# CITY OF ALBUQUERQUE

PLANNING DEPARTMENT – Development Review Services

**RE: 101.7 The Team Radio  
Drainage Report, Grading and Drainage Plan  
Engineer's Stamp Date 11-25-2014 (File: C12D026)**

CITY PROJECT NO. 702182 ZONE MAP NO. C-13/D-13 SHEET 3 OF 4

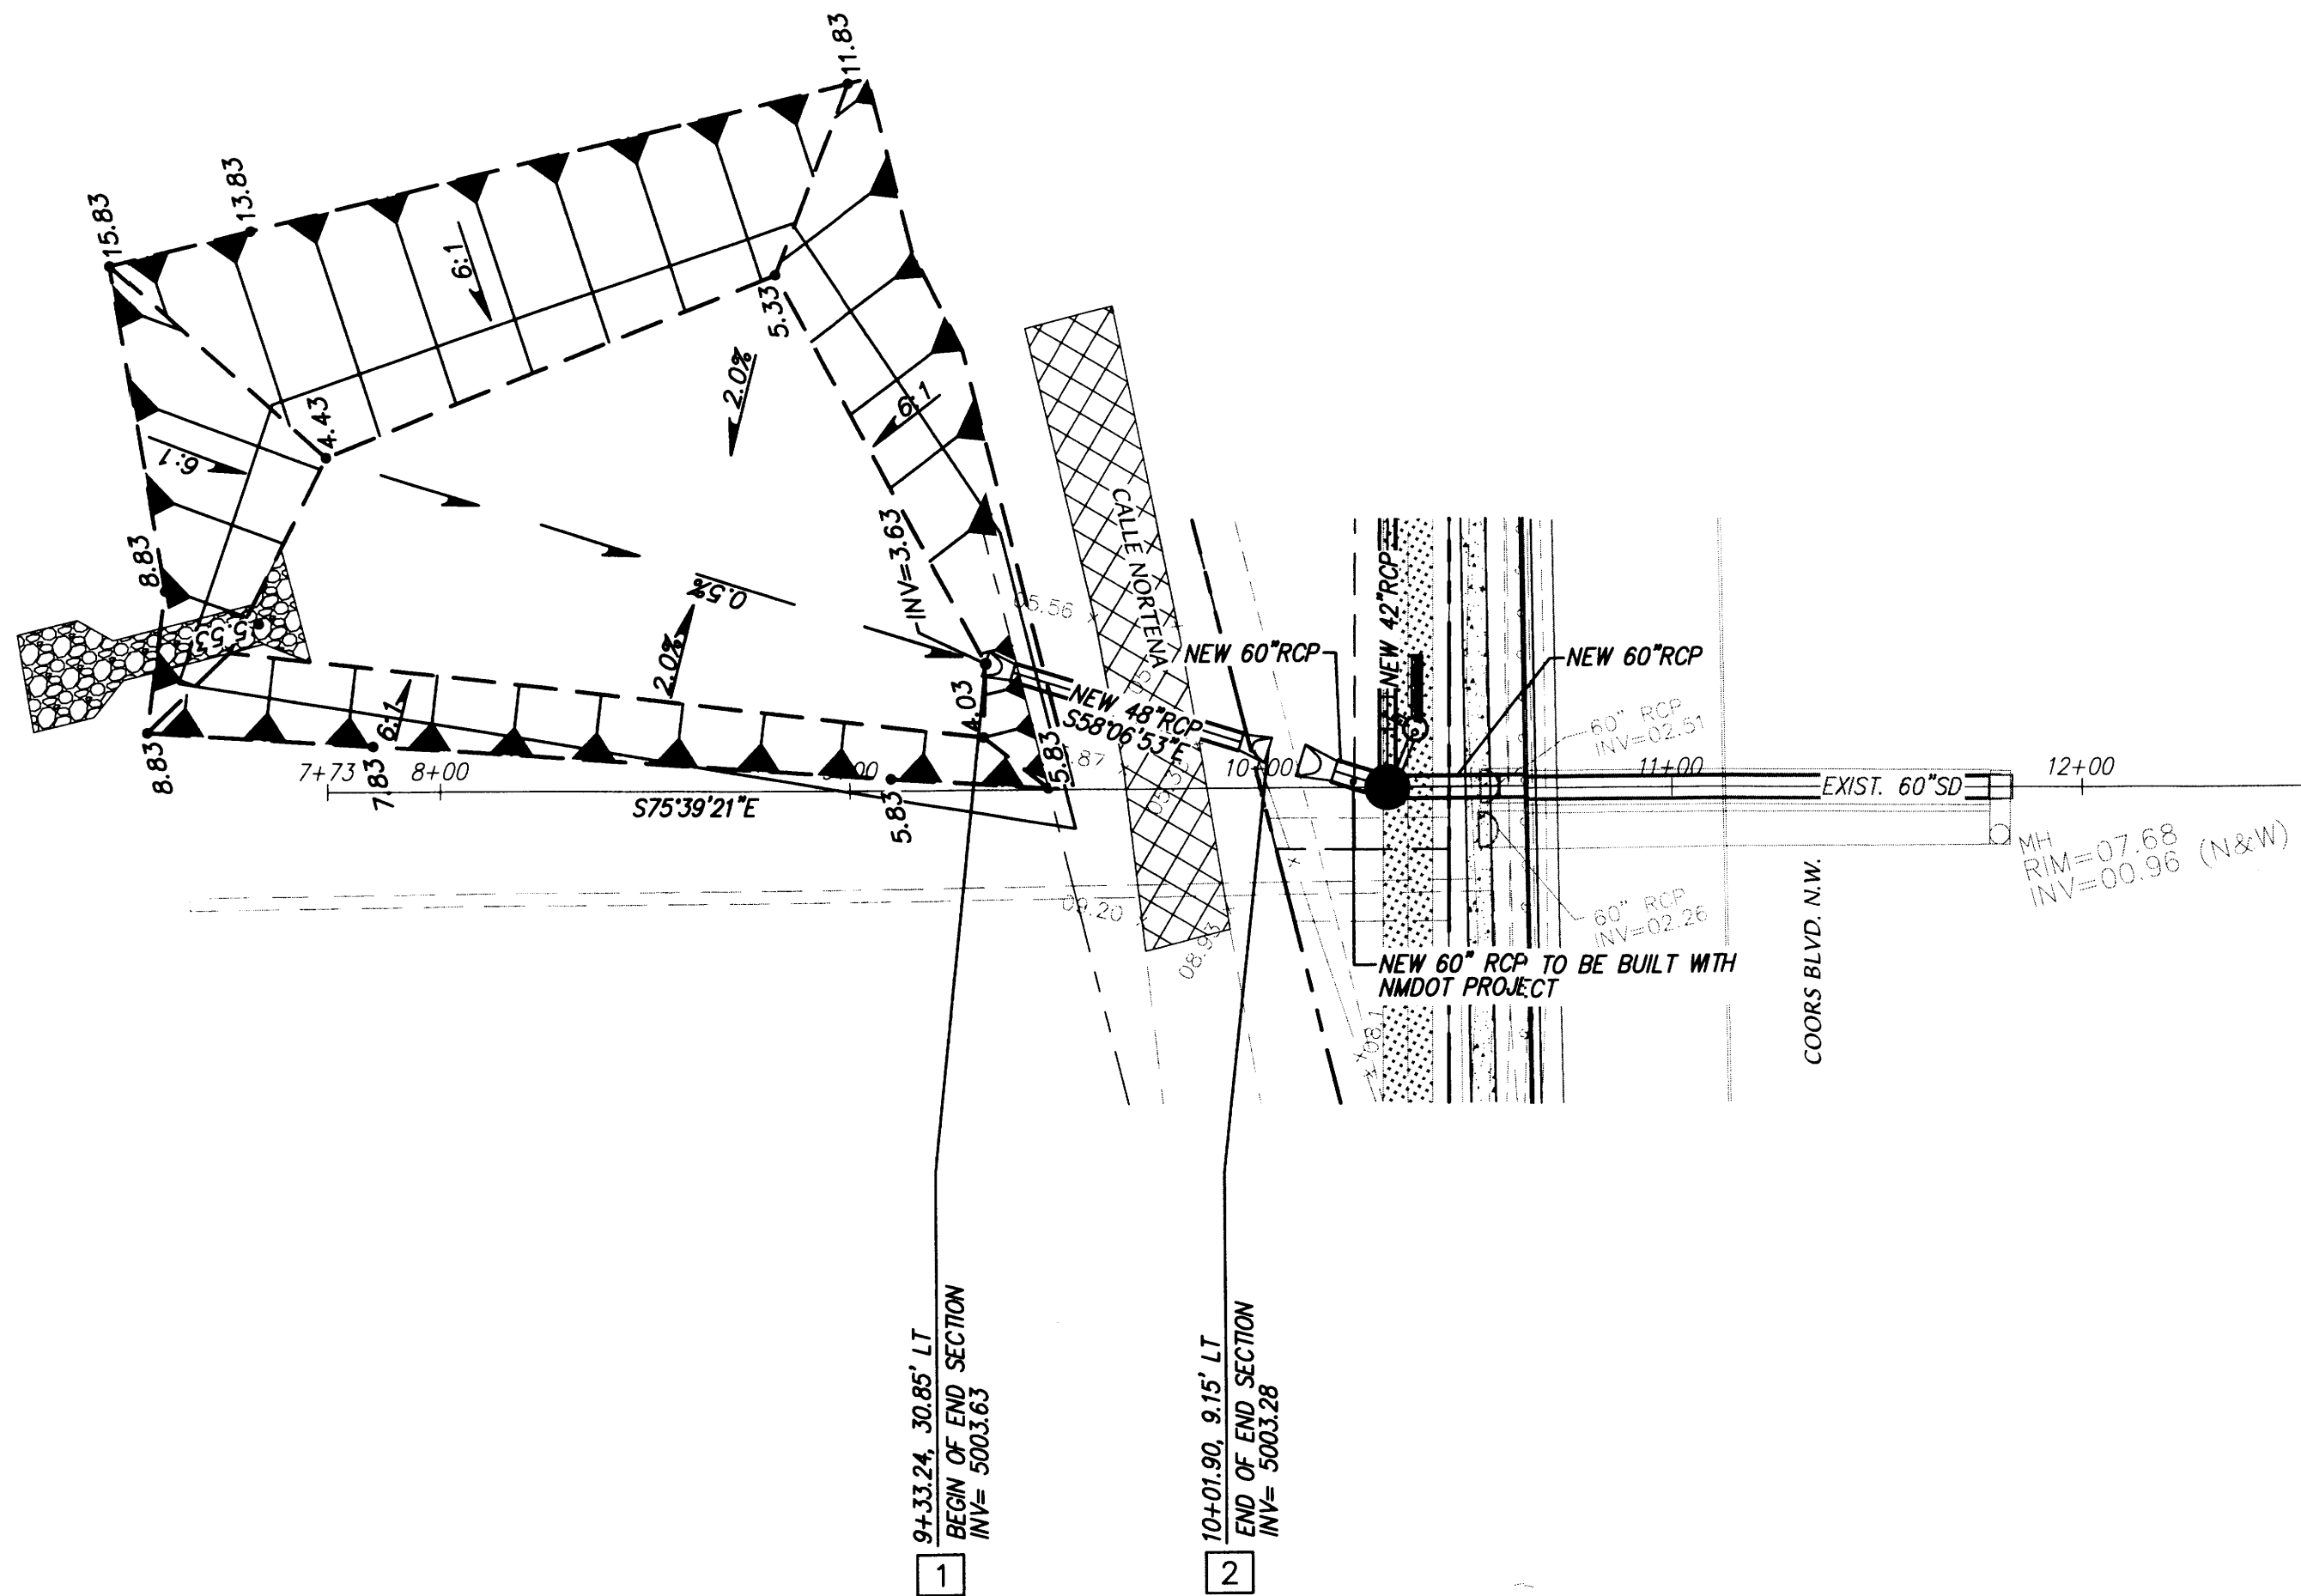
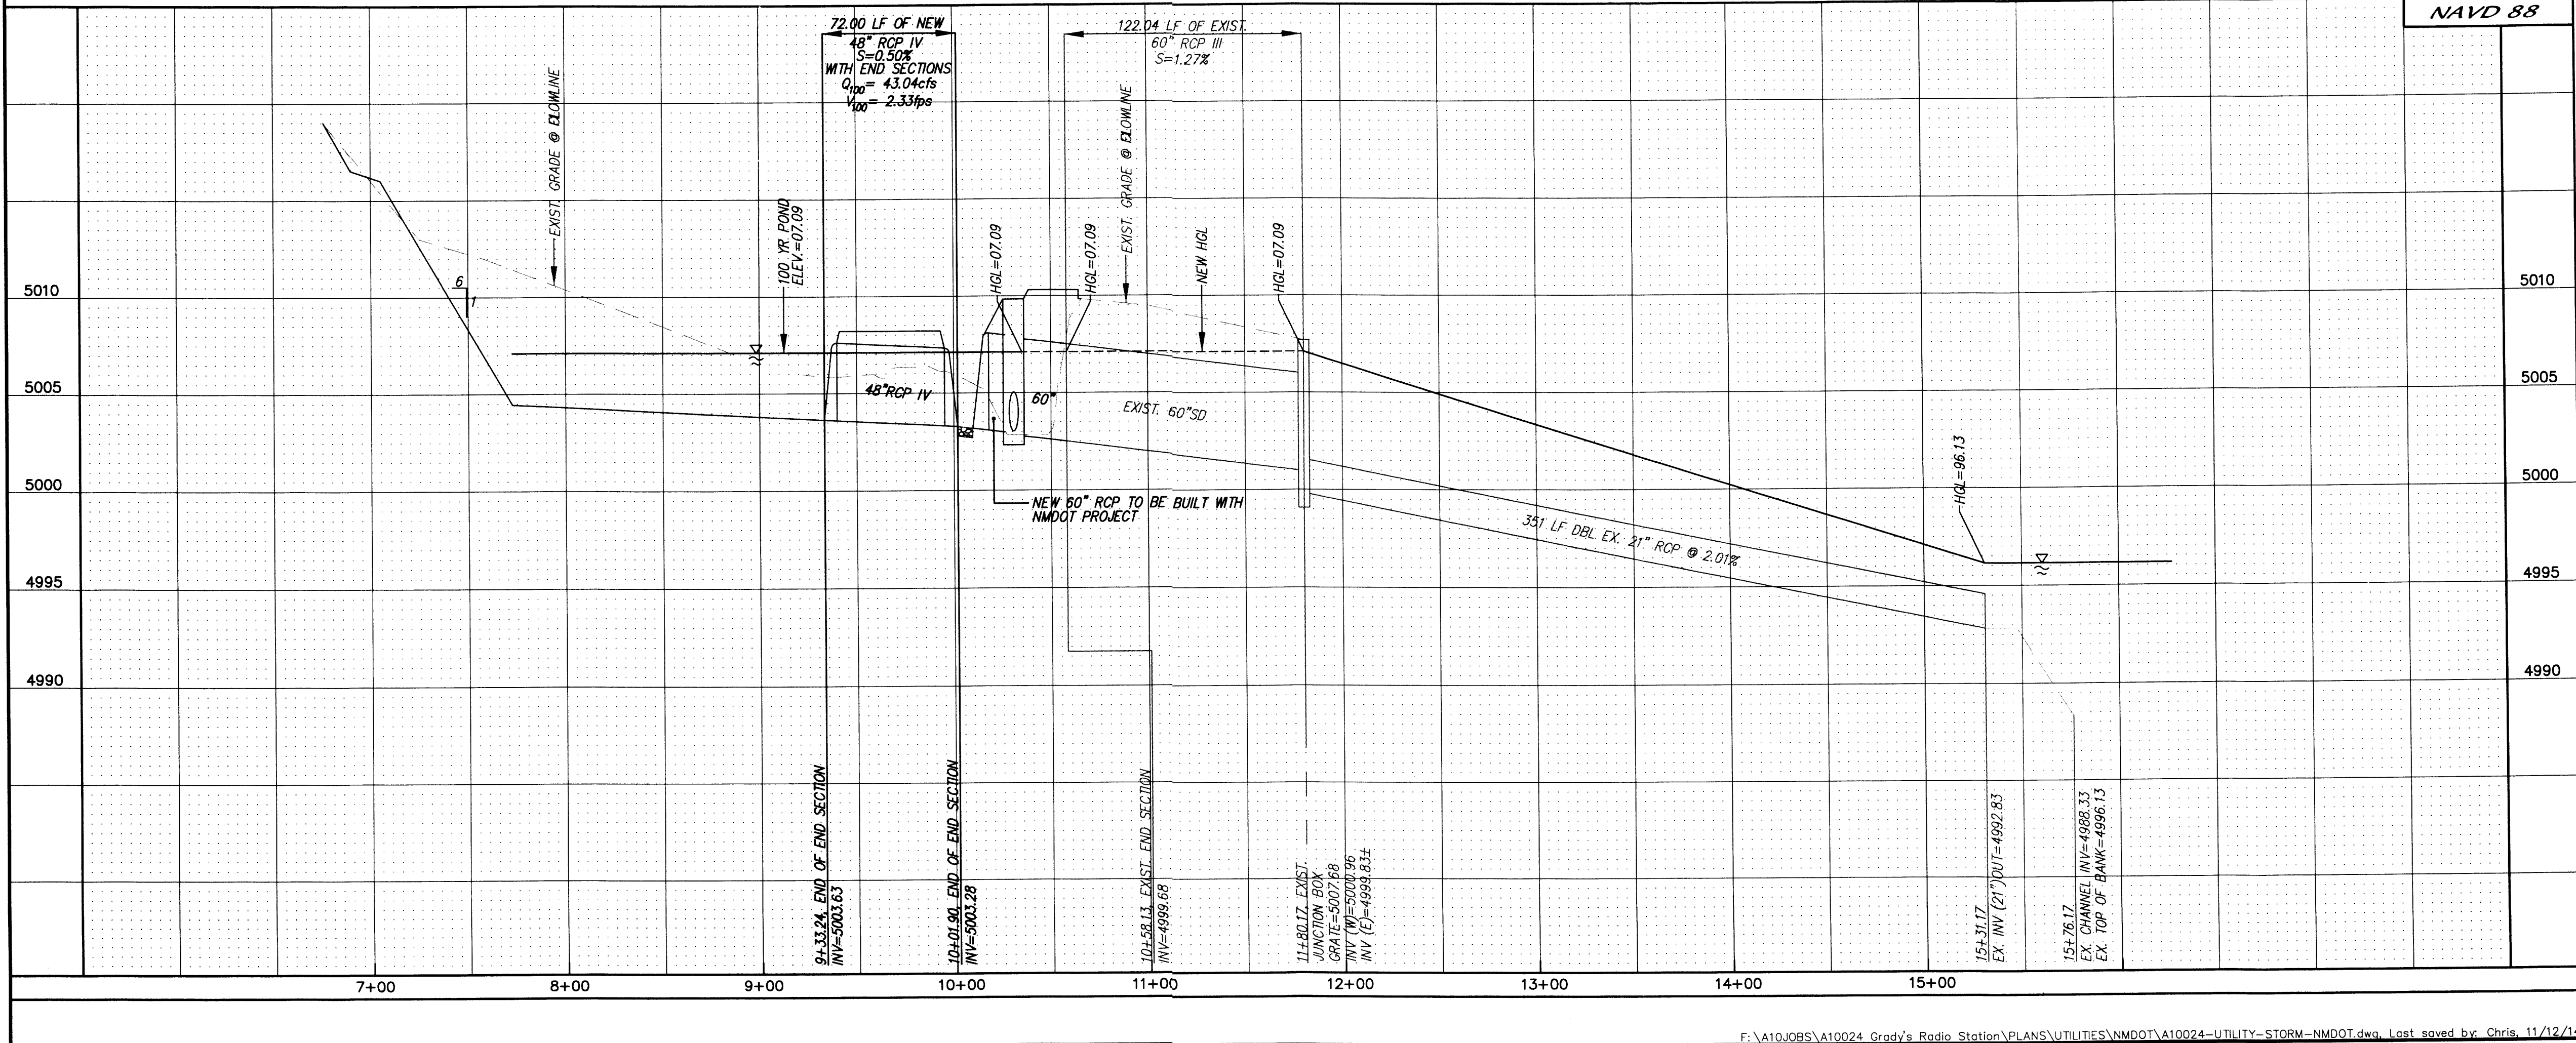
1. Approval from NMDOT and the County are required. Emails with Tim Trujillo and Don Briggs will suffice.
2. Various easements, Agreements and Covenants are needed prior to DRC signoff.
3. Show roof discharge locations
4. In order for the pond limits to be clearly delineated (100 yr WSEL) can the spot elevation at the curb cut be raised from 5007.03 to 5007.09?
